**Consultation Response from KC,
Lead Local Flood Authority**
2021/90605 land at, Vanguard Processing Equipment, Spa Fields Industrial Estate, Slaithwaite, Huddersfield, HD7 5BB
Erection of an industrial building (B1(c) use)
**Date Responded:
31 March 2021**
**Responding Officer:
Aleksandra Tomczyk**
Responding Ref: 0
Summary

Kirklees Flood Management and Drainage, as the Lead Local Flood Authority (LLFA), **OBJECT** to this planning application and require **FURTHER INFORMATION** is provided on the following:

GA Site Layout Plan

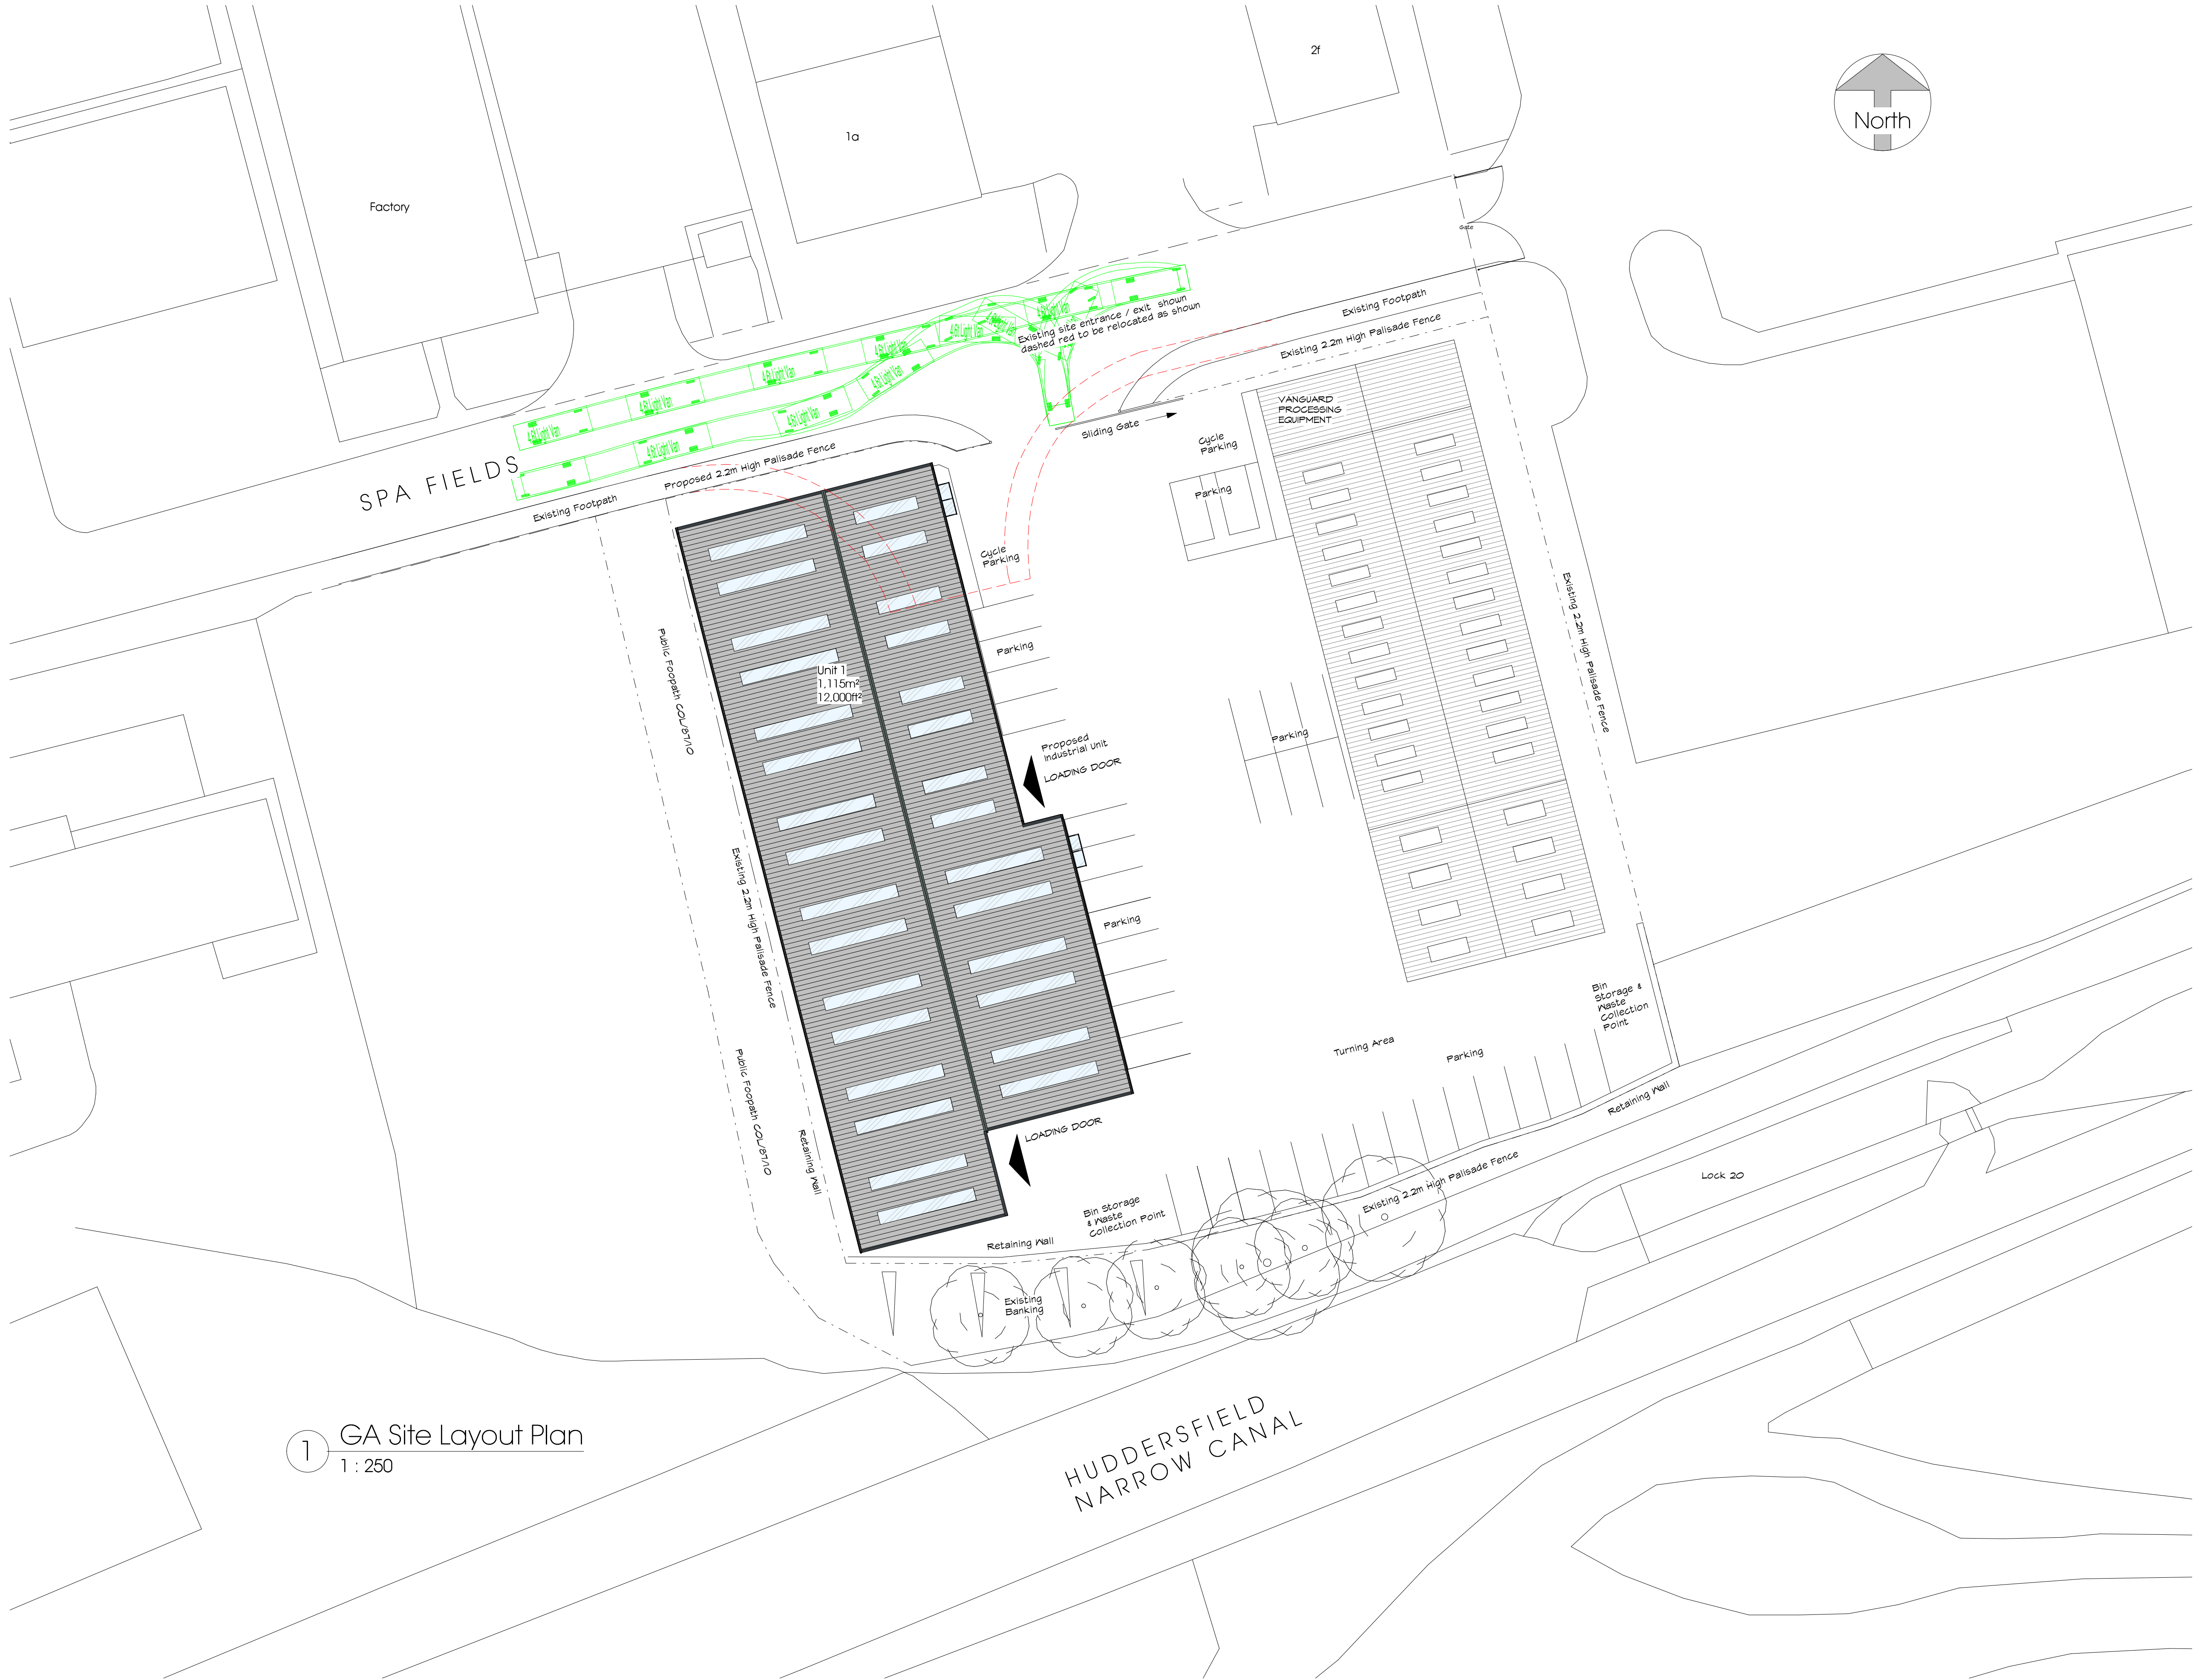
The only information on the management of surface water on site has been provided within the Application Form, which states that the flows will be accommodated within the existing surface water drains on site.

The applicant should confirm the location and condition of these drains. The discharge point of the system should also be confirmed. This information should be provided to the LLFA for review.

If any increase of impermeable area on site is proposed, the applicant should also provide an assessment of how this increase will impact the existing system.
